**CONSULTATION UNDER THE TOWN AND COUNTRY PLANNING
(DEVELOPMENT MANAGEMENT PROCEDURE ENGLAND) ORDER 2015**

Planning Application Reference:	BN/65/22/PL
Proposal:	Sever land and erection of 1 No bungalow with new vehicular access (resubmission of BN/14/22/PL). This application is a Departure from the Development Plan and is in CIL Zone 3 and is CIL Liable as new dwelling.
Location:	Land at rear of Cedar End Eastergate Lane Eastergate PO20 3SJ
Date:	30 August 2022

The Portsmouth Water Catchment Management Team have reviewed the outline application from a groundwater quality protection perspective and have provided the following comments.

Proposed Site Plan
1:200

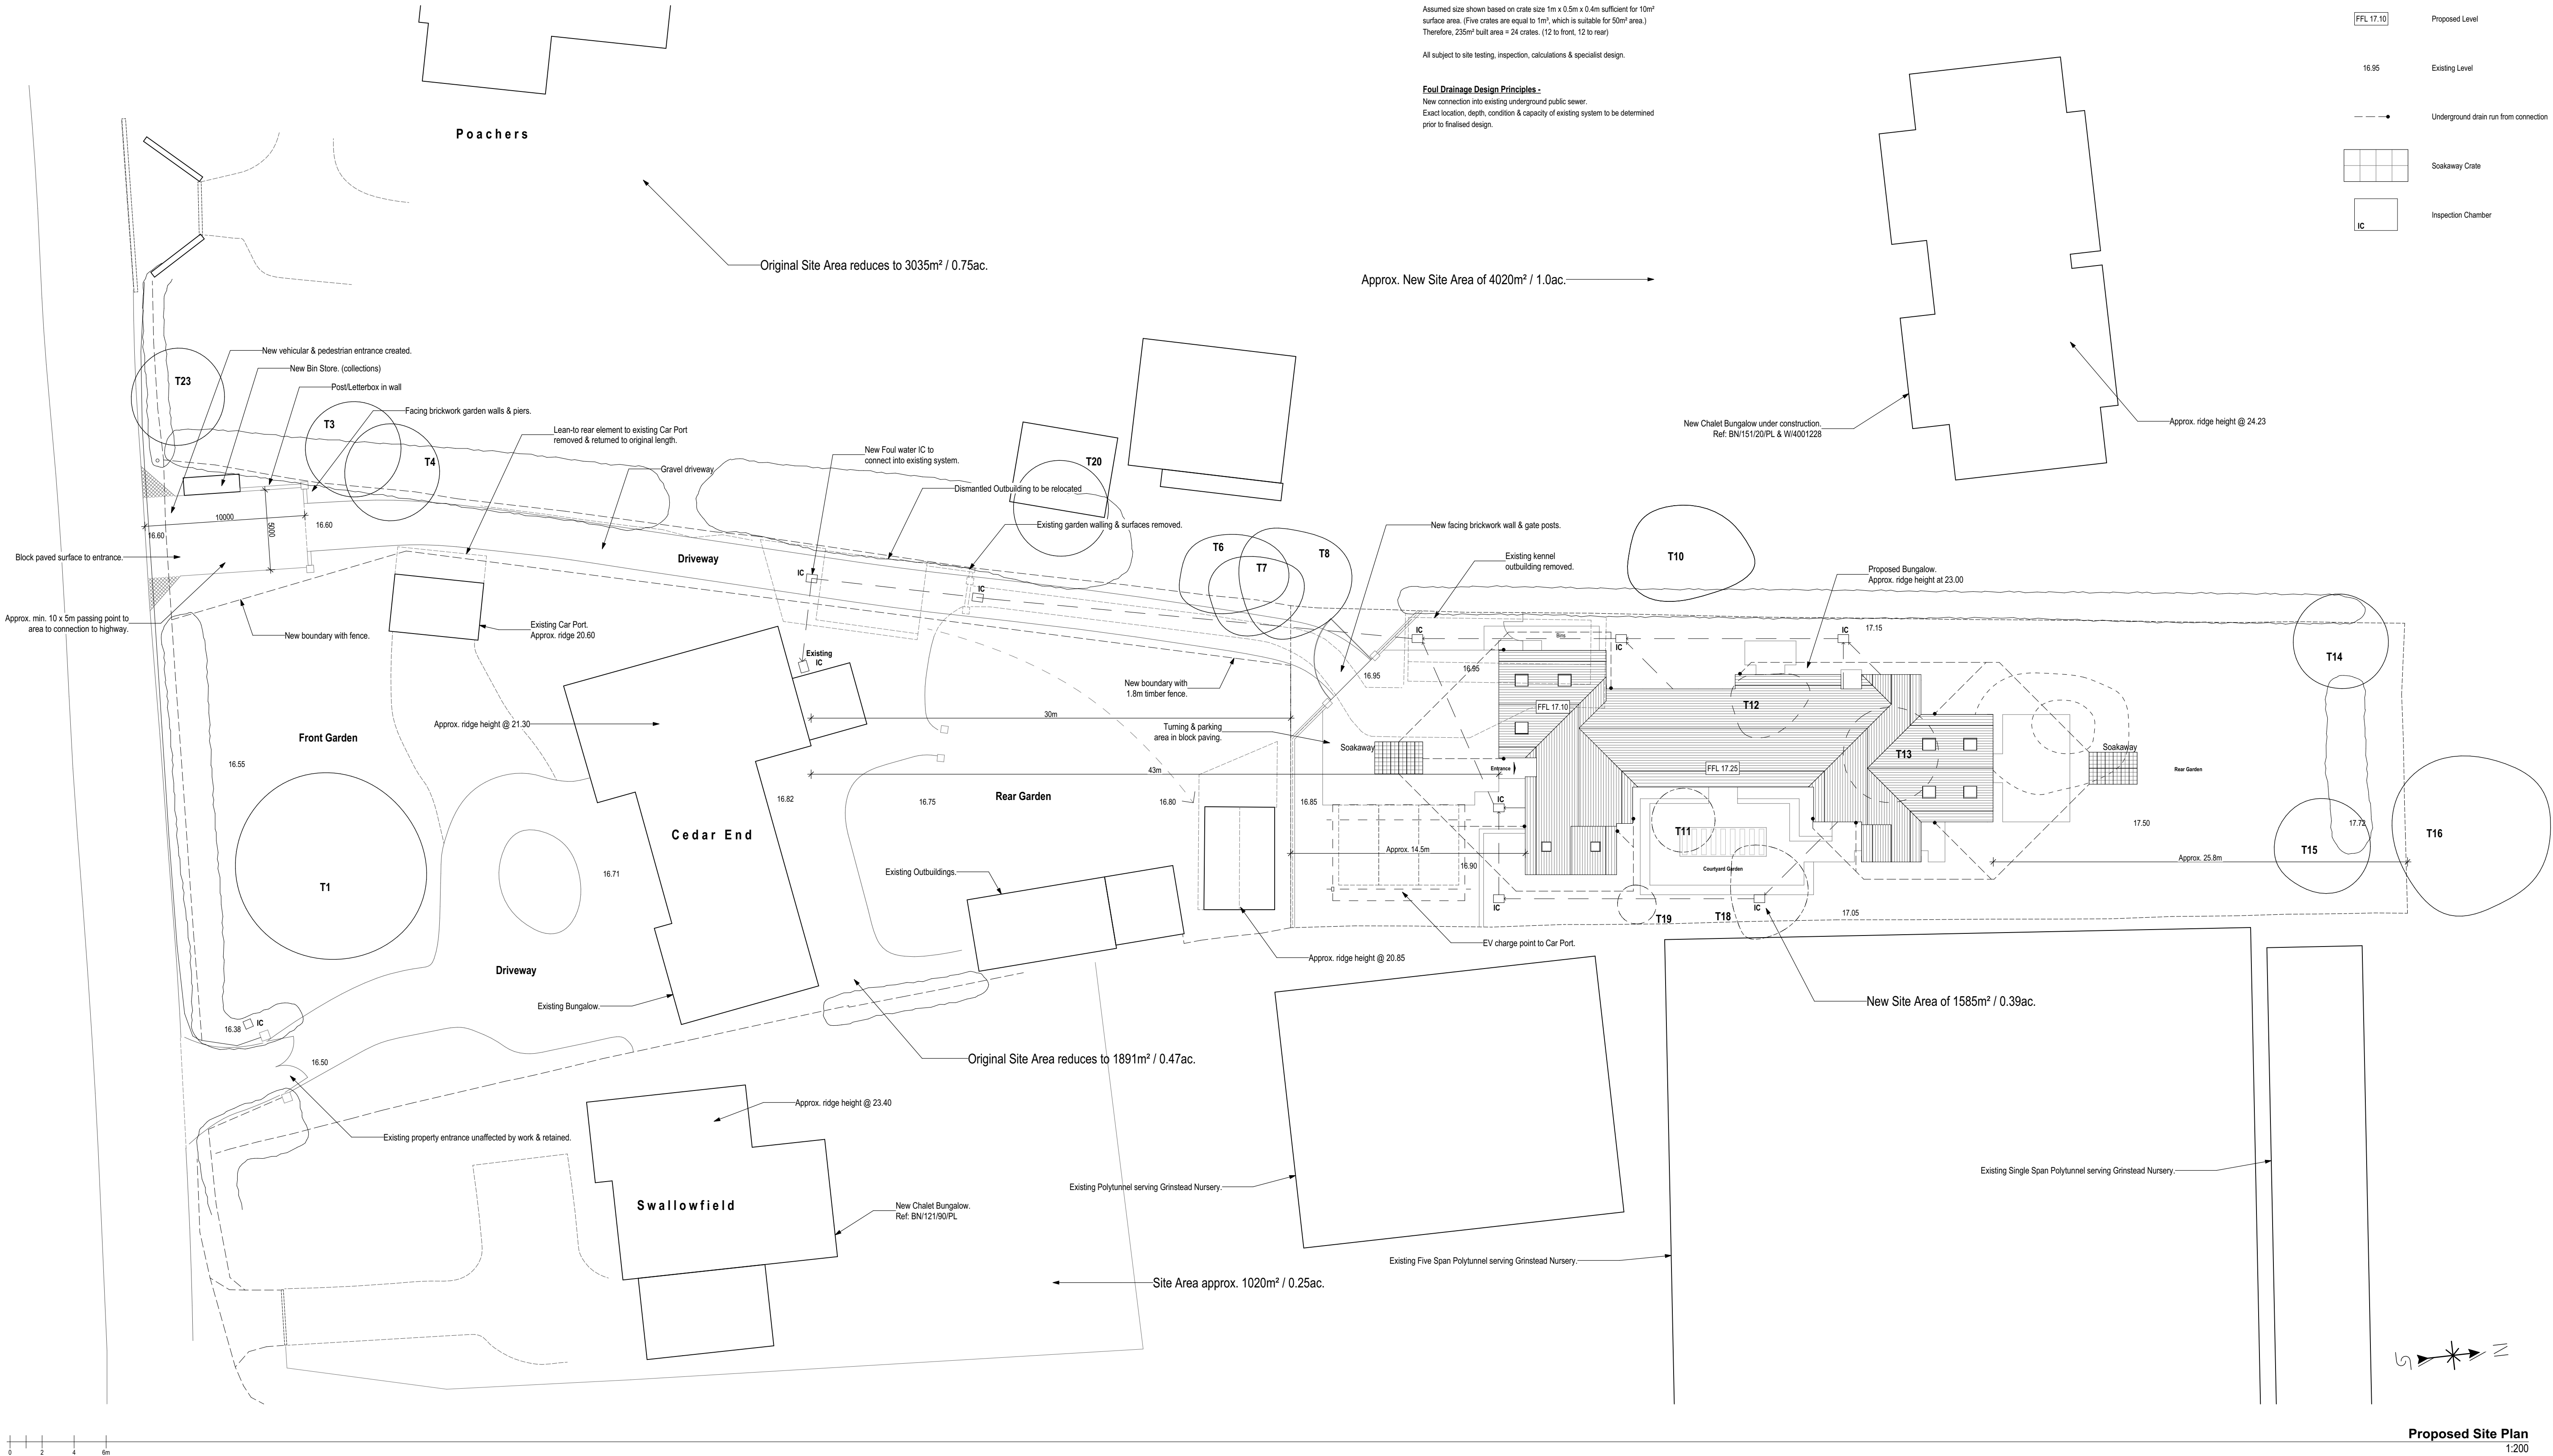
The proposed surface water drainage strategy is disposal via infiltration, on the proposed site plan two soakaways are proposed, one at the front and one at the rear of the property.

There is no further information provided on the surface water drainage. According to the CRICA SUDs manual the pollution hazard from roof water is defined as 'very low', however there is still a requirement for removal of gross solids and sediments. It is not clear from the information if the system will include this pollution mitigation. Furthermore, it is unclear how the drainage from the driveway will be disposed of. Residential car parks and individual property driveways with low traffic movements have a 'low' pollution hazard and requires

further treatment than roof water. We request further information is provided on the surface water drainage proposal including the pollution mitigation, management and maintenance plan.
